**From:** Alex Shutt  
**Sent:** 18 February 2022 16:07  
**To:** Nicola Hopkins  
**Subject:** RE: The Dog Inn

Following on from our site visit yesterday please see below regards trees and biodiversity.

**Application Number: 3/2021/0275**  
**Proposal: Proposed erection of 8 new dwellings and associated works.**  
**Location: Land Behind The Dog Inn Market Place Longridge**

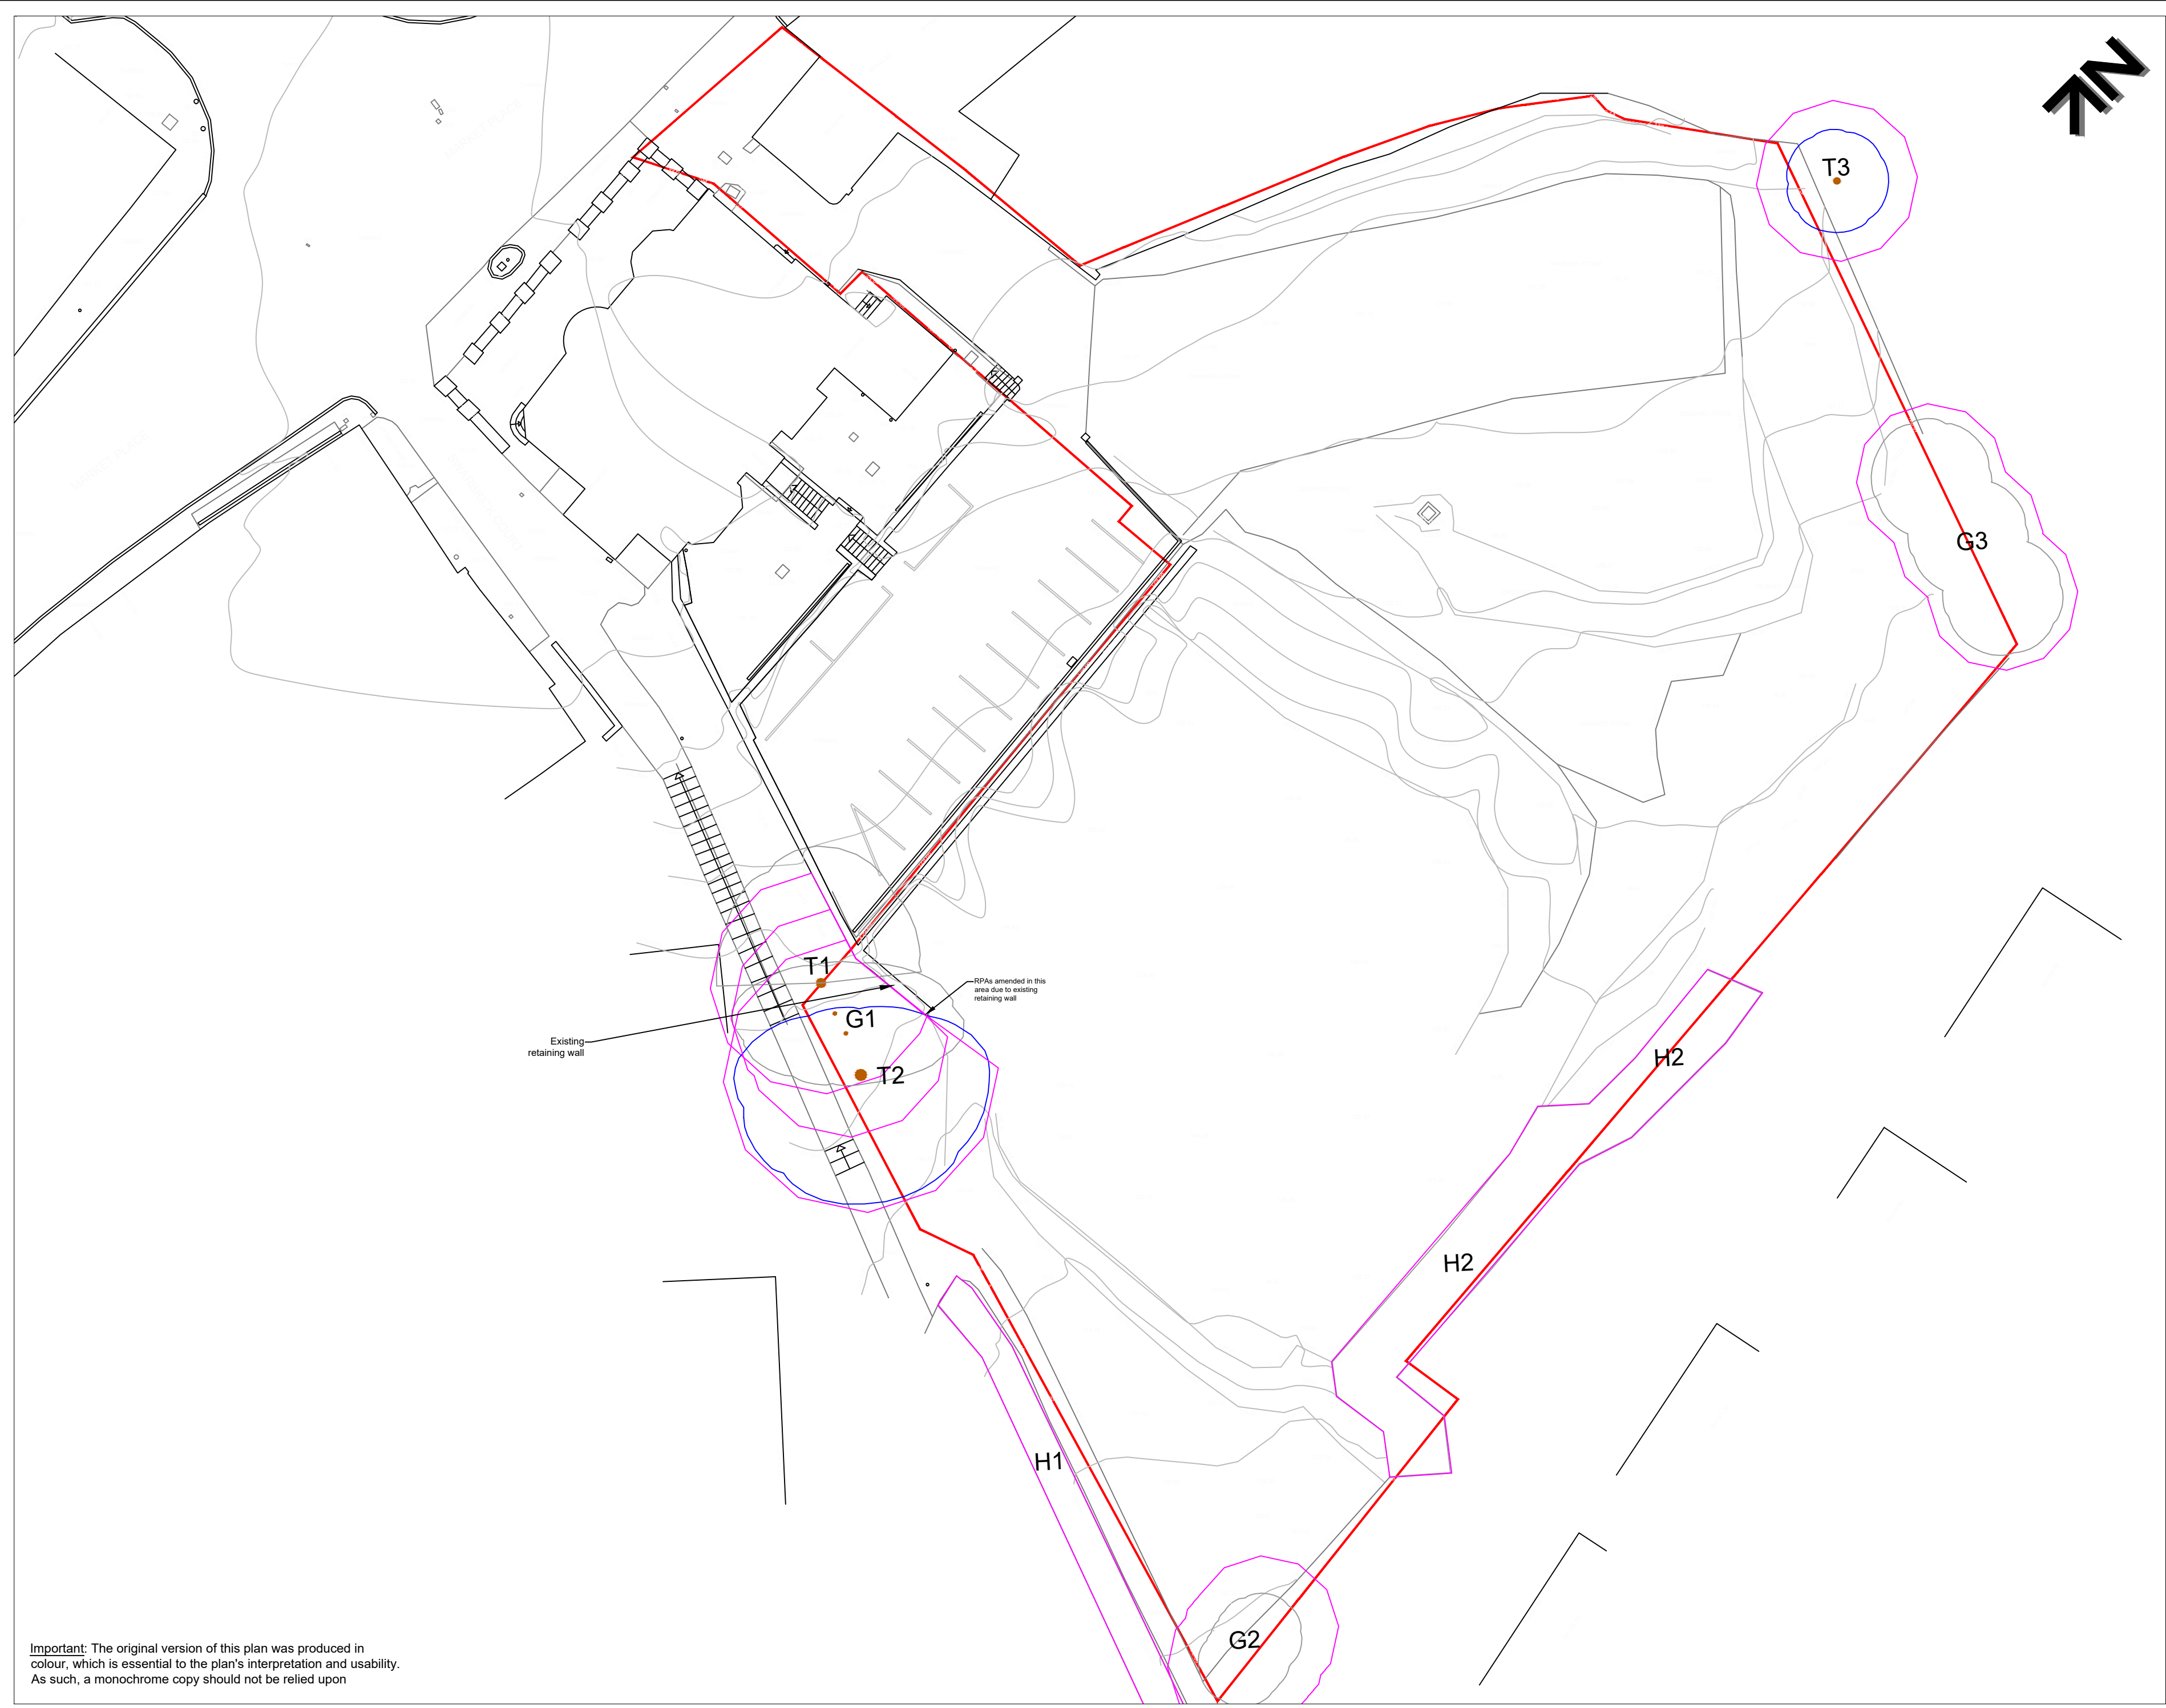
T1 & G2 = Although they offer very good habitat value particularly to nesting birds, the retention within the proposed development is not realistic due to their suppressed form, tight unions and low retention category. If this development is approved then it should be with these trees removed, albeit after the current nesting season or any future nesting season.

T2 = Requires the heavy ivy stripping from the tree firstly to ascertain whether or not it is suitable for retention /protection and to increase its safe useful life expectancy by removing the false sail weight. Again albeit after the current nesting season or any future nesting season, due to the high habitat potential. I would request a prior to commencement condition for this work.

T3 = Is borderline justified for a TPO primarily due to species and young age but it is third party so just needs the RPA's to be protected throughout the development process as is with the rest of the 3<sup>rd</sup> party or shared boundary vegetation as outlined within the AIA.

I could not see any bird or bat box plan submitted with the application which is a requirement for biodiversity enhancement as well as mitigating the potential loss of habitat, T1 and G1.
